Glendell Continued Operations Project (SSD-9349) - Review of Environmental Impact Statement

Glendell Continued Operations Project (SSD-9349) – Review of Environmental Impact Statement

Glendell Continued Operations Project (SSD-9349) – review of Environmental Impact Statement

Figure 9: Yorks Creek Realignment Conceptual Design

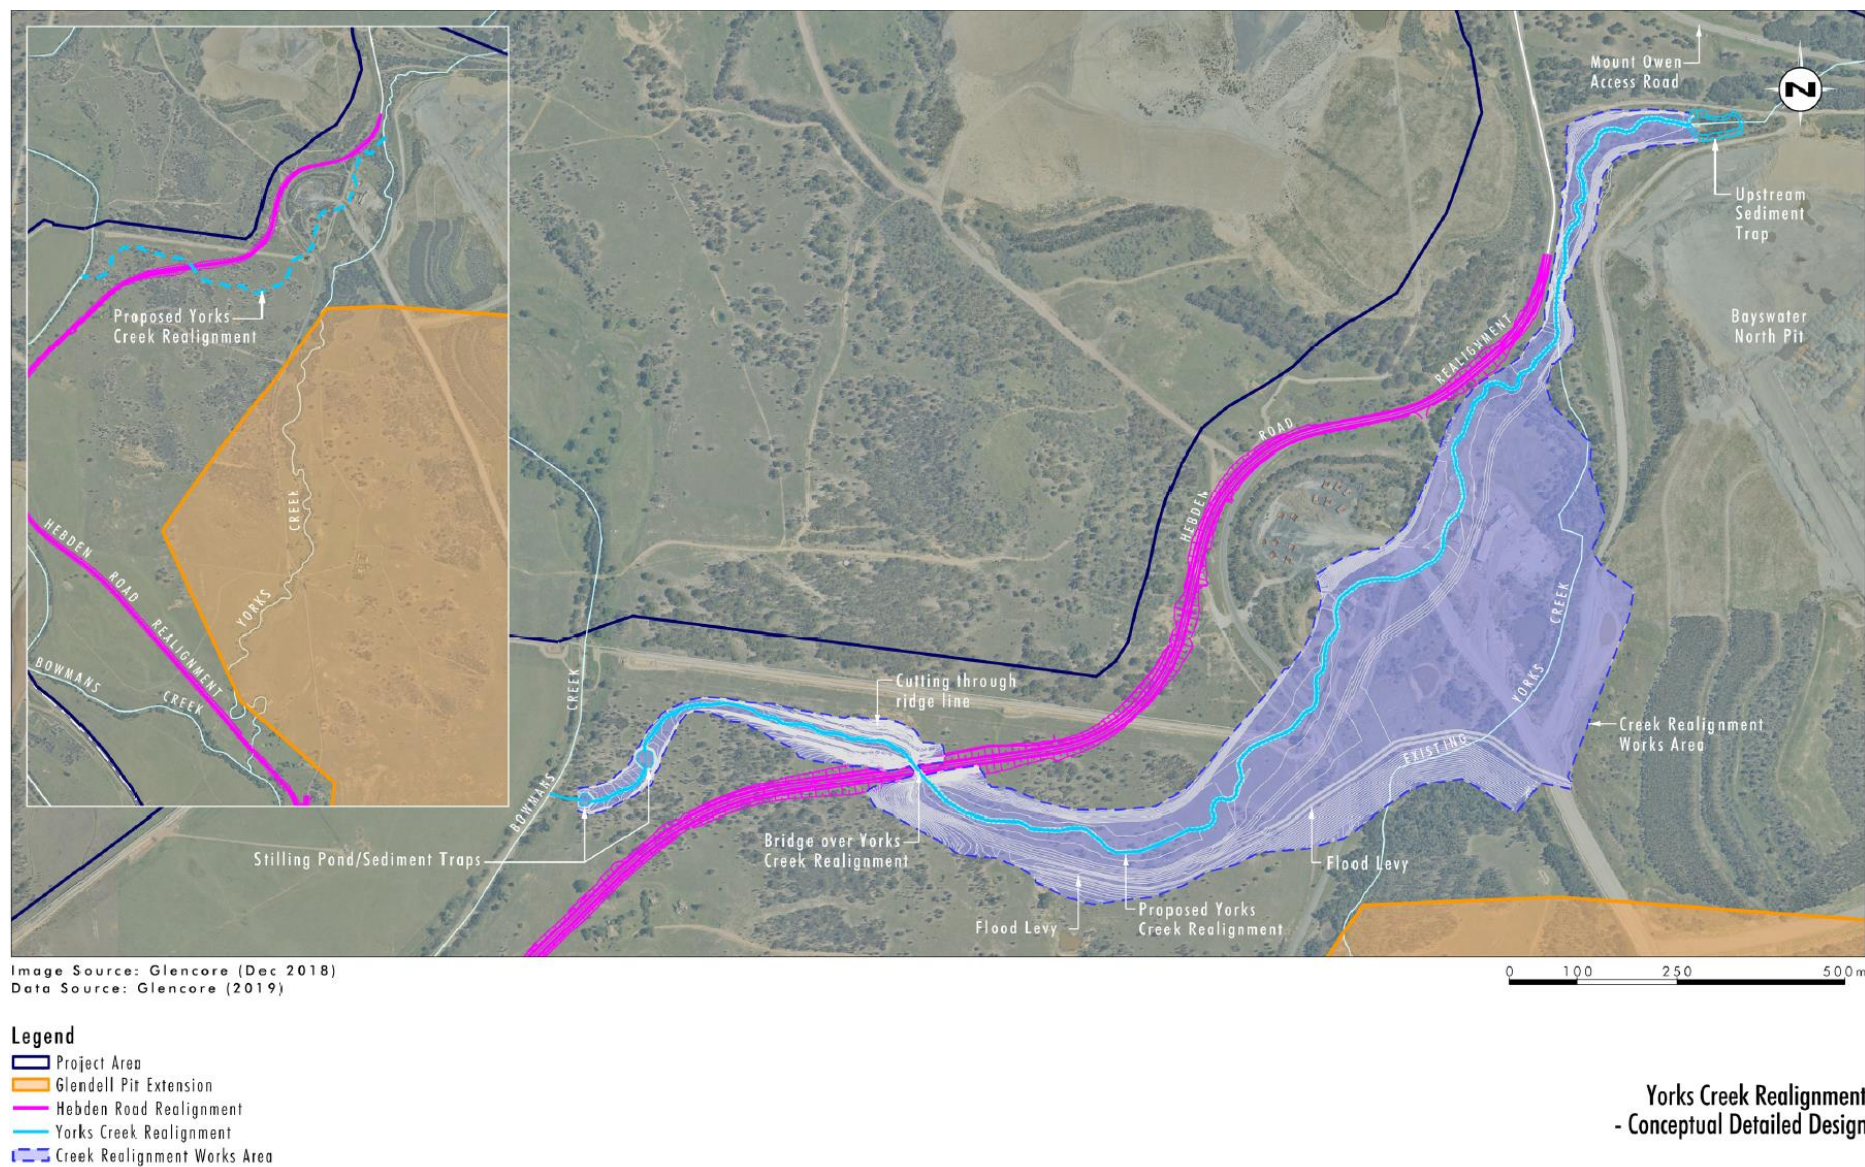
2. Landscape features should include Yorks Creek

Yorks Creek is a Strahler 4th-order stream that flows through the proposed development footprint. However, it has not been included in the Biodiversity Assessment Method (BAM) calculation. This detail can be added in the calculator file in Tab 2 'Site context' under landscape features by selecting 'rivers and streams', then adding the name of the creek as free text. BCD recommends that those details are added to the calculator file and the calculator file is re-run.

BCD recommends that Tab 2 of the BAM calculator file is updated to include 'Rivers and streams'; as a landscape feature, to show that Yorks Creek crosses the proposed development footprint, and that the BAM calculator is re-run.
